Recommendation Report for Planning Permission for Works or Extension to a Dwelling

REF NO: Y/58/20/HH

LOCATION: Rosemary Cottage
Bilsham Road
Yapton
BN18 0JG

PROPOSAL: Loft conversion and rear infill.

Proposed North Elevation

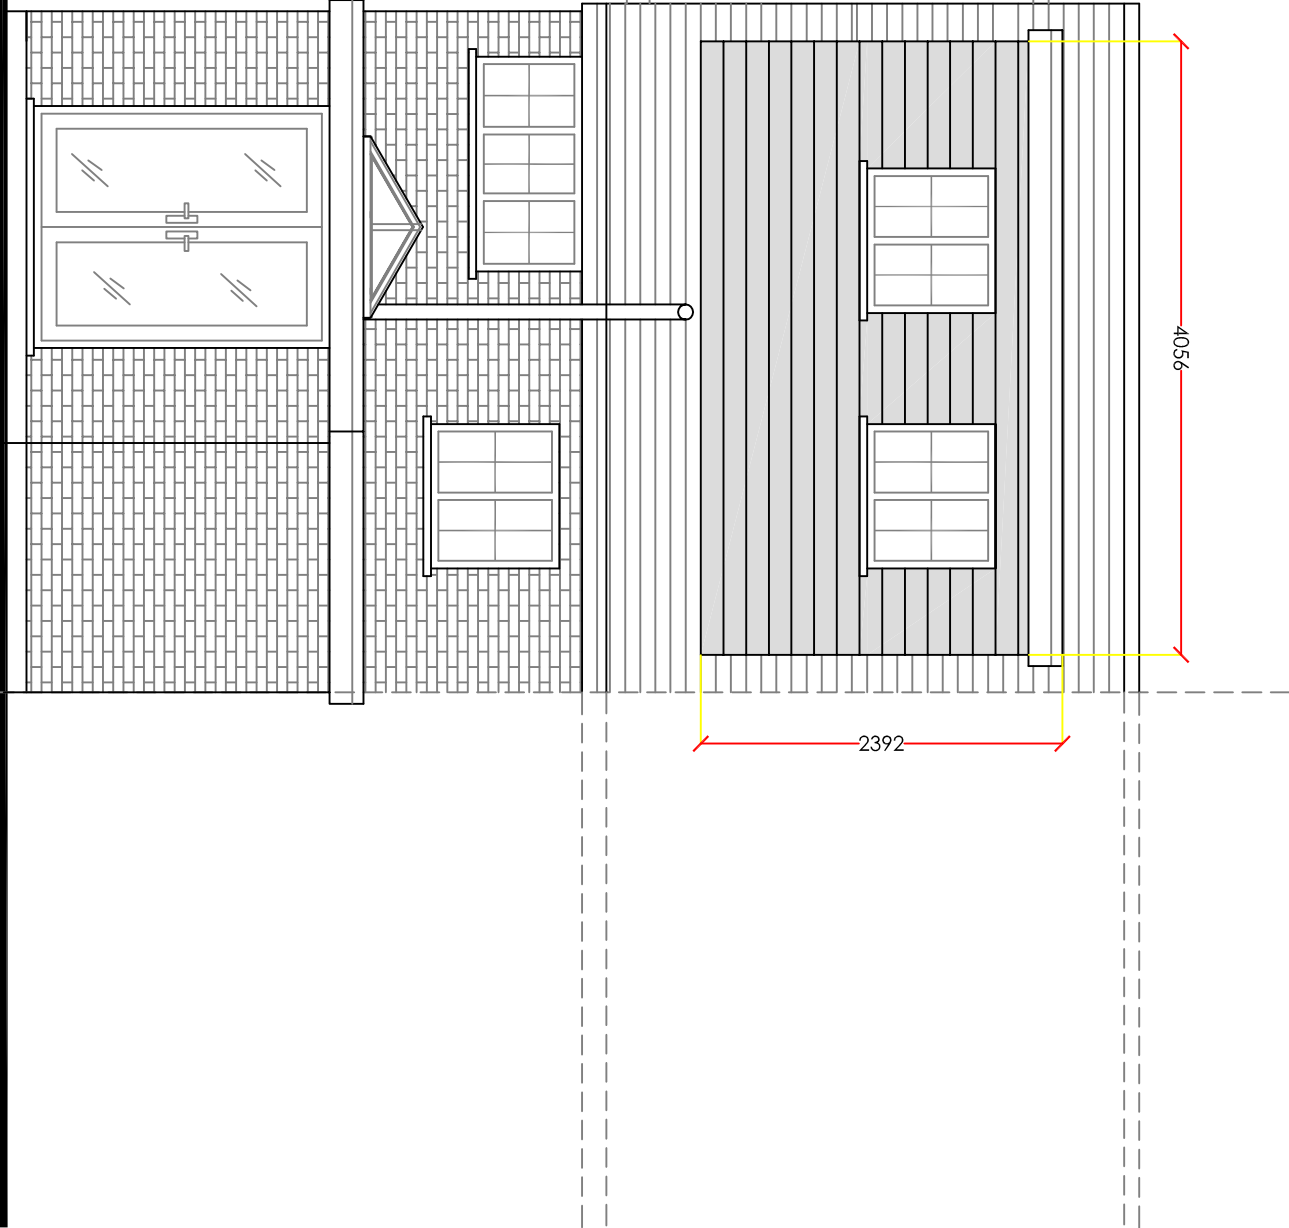
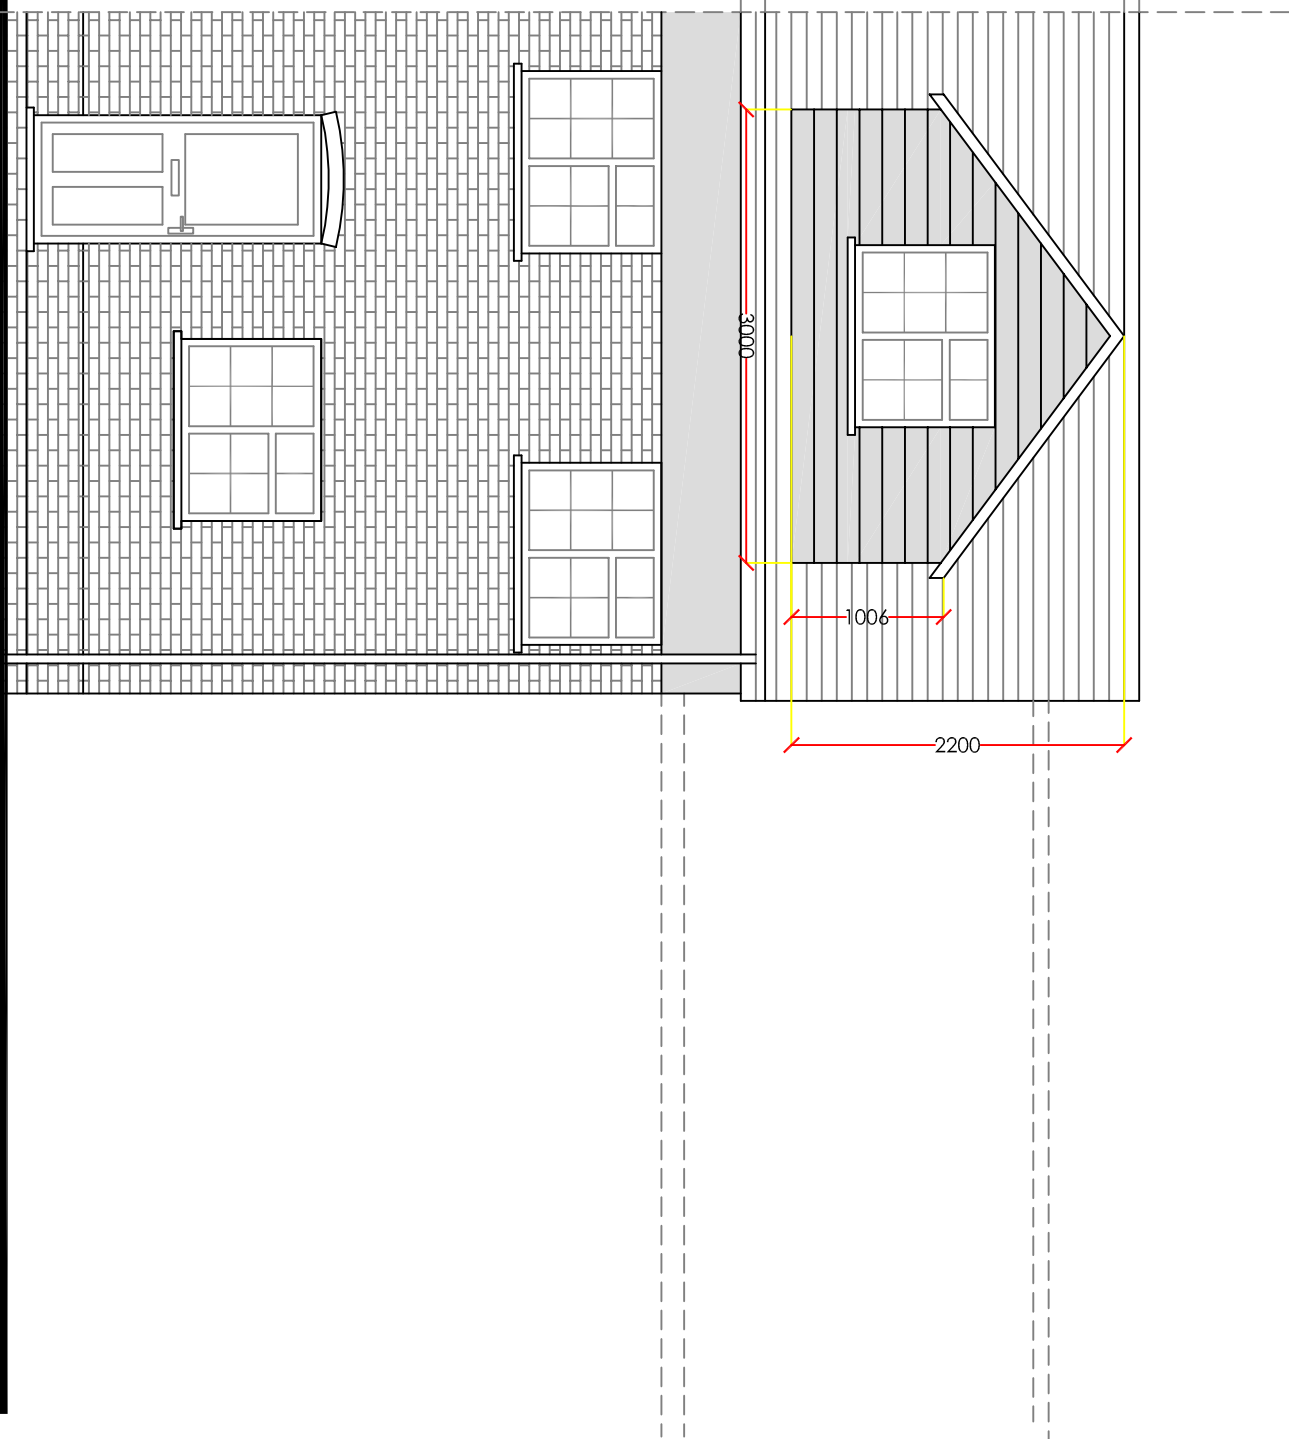
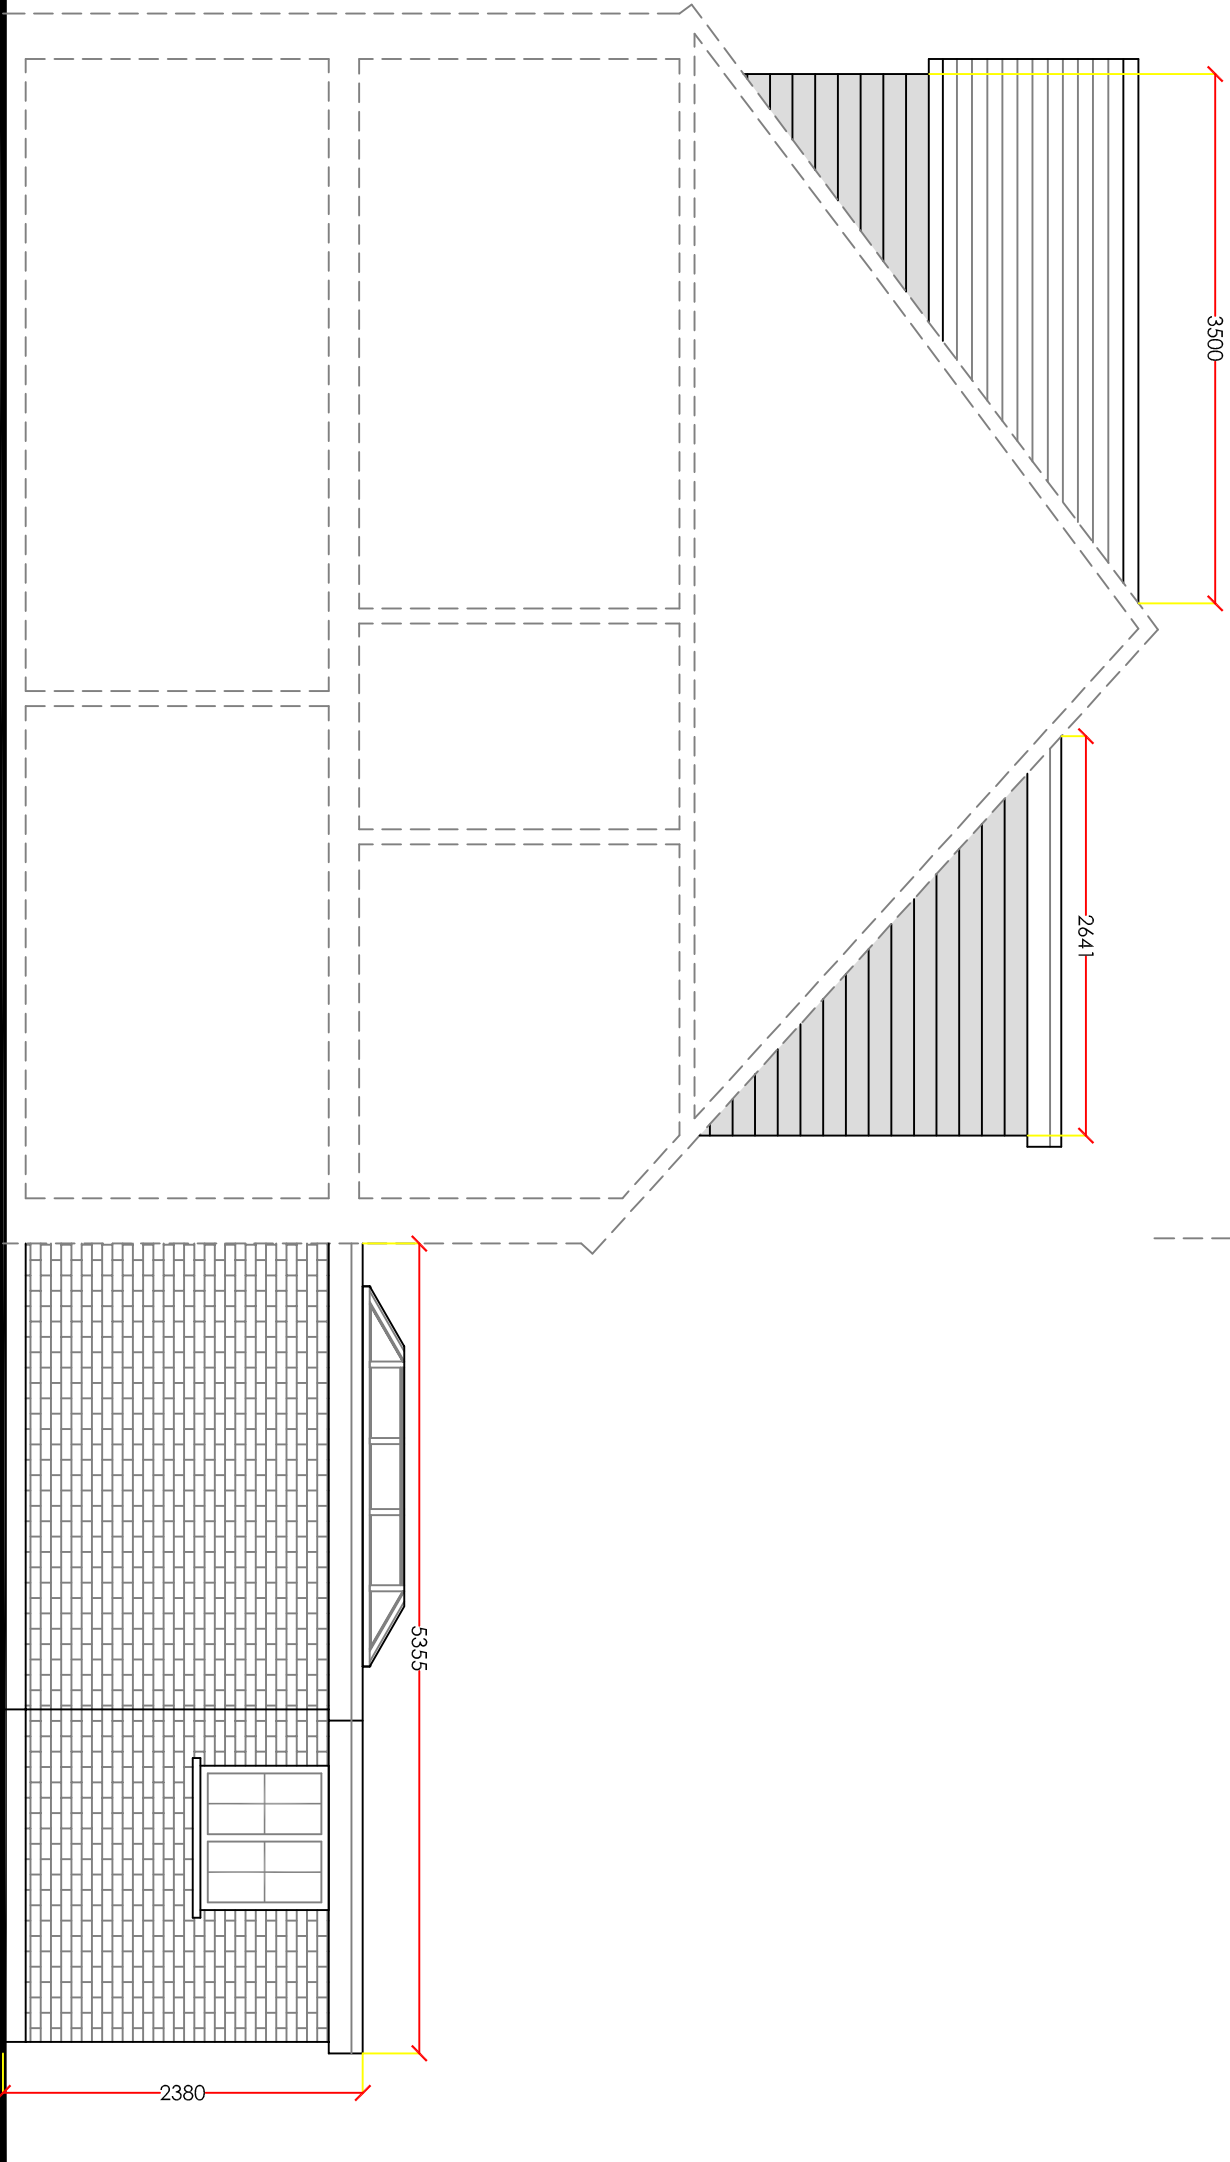
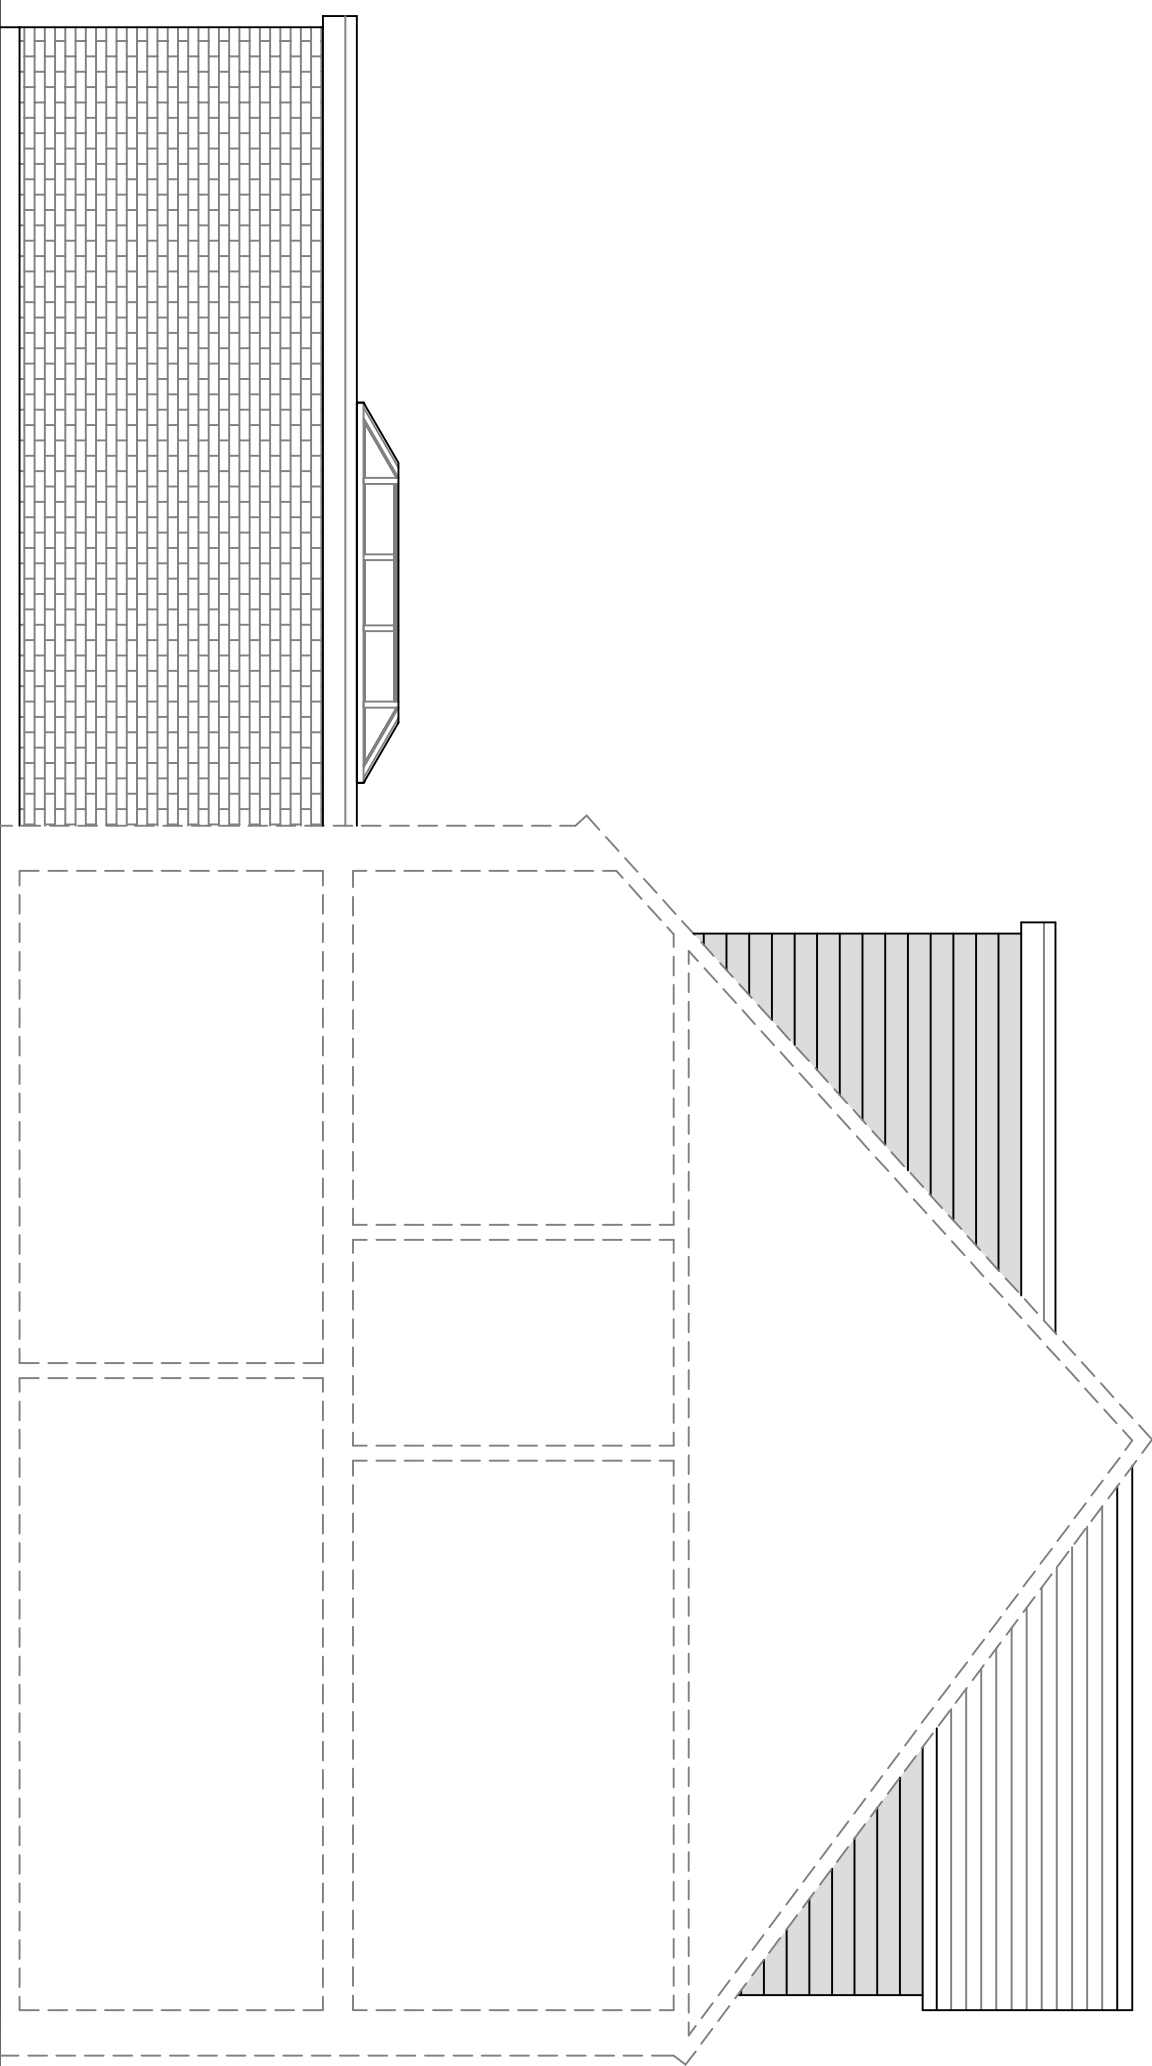
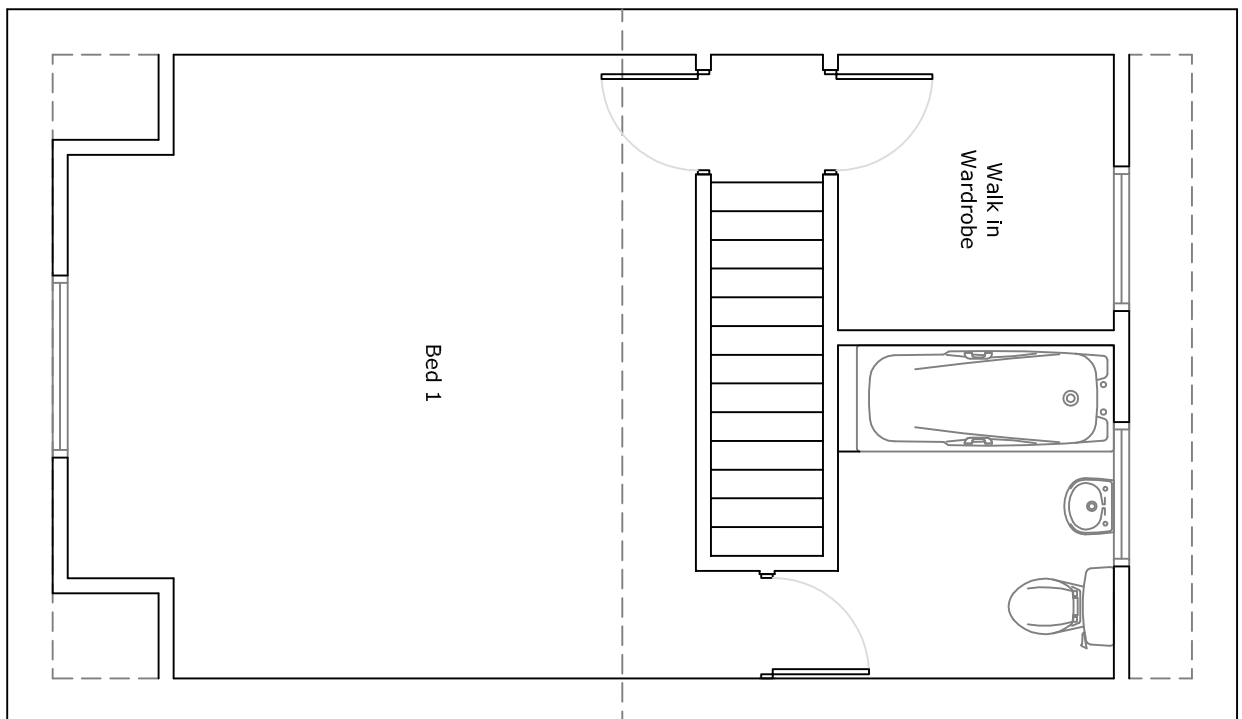
The dormer to front and rear will consist of both a flat roof and a gable roof. The dormer would overlook the street scene at Belmont Terrace which are predominately the front gardens of the surrounding properties. The immediate neighbours have rear gardens facing Belmont terrace similar to the host dwelling, however also have additions similar to that proposed and with a larger garden to the south of these properties, the dormer is not considered to provide adverse overlooking.

To the west of the property, there are 2 dwellings (1 & 2 Portland Head) with gardens extending east towards the host dwelling. The dormer to the south would look towards these gardens although any views achievable are not considered to be significant. The neighbouring properties to the west have existing structures to the rear gardens which take up the majority of the garden space and therefore any views into the private amenity space is minor.

There are two windows to the rear elevation of the properties to the west however these serve bathrooms and with obscured glazing, the dormer is not considered to provide significant views.

There are also 2 windows to the side elevation of Claremont situated to the rear however due to the siting with around 14m, views are not considered significant.

Proposed Ground Floor Plan

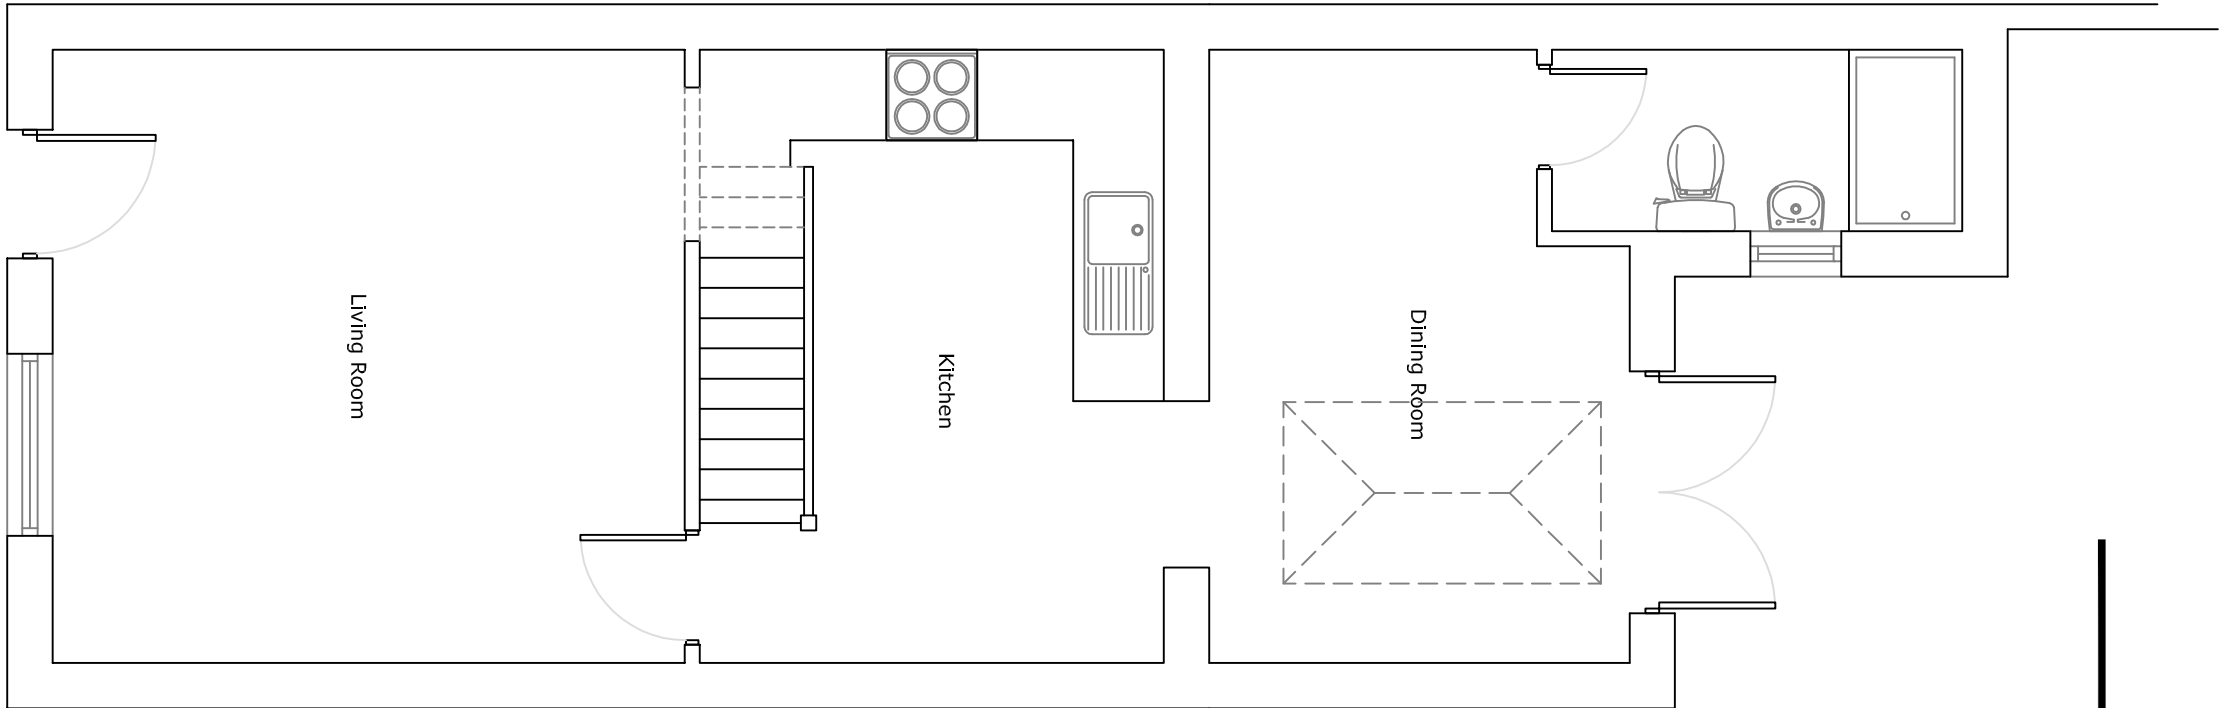
The extension to the north of the property largely replaces an existing structure with the same depth proposed. There is however a small increase in width to part of the extension which forms a bathroom increasing from 1.2m to 1.65m.

The height will be 2.35m which is around the same as existing except will form a flat roof instead of a lean to. There will also be a roof lantern to a protruding an additional 0.25m.

The neighbouring properties have similar additions to the north which extend up the boundary, similar to that proposed. As such, the extension is not considered to result in adverse overbearing, overshadowing or overlooking.
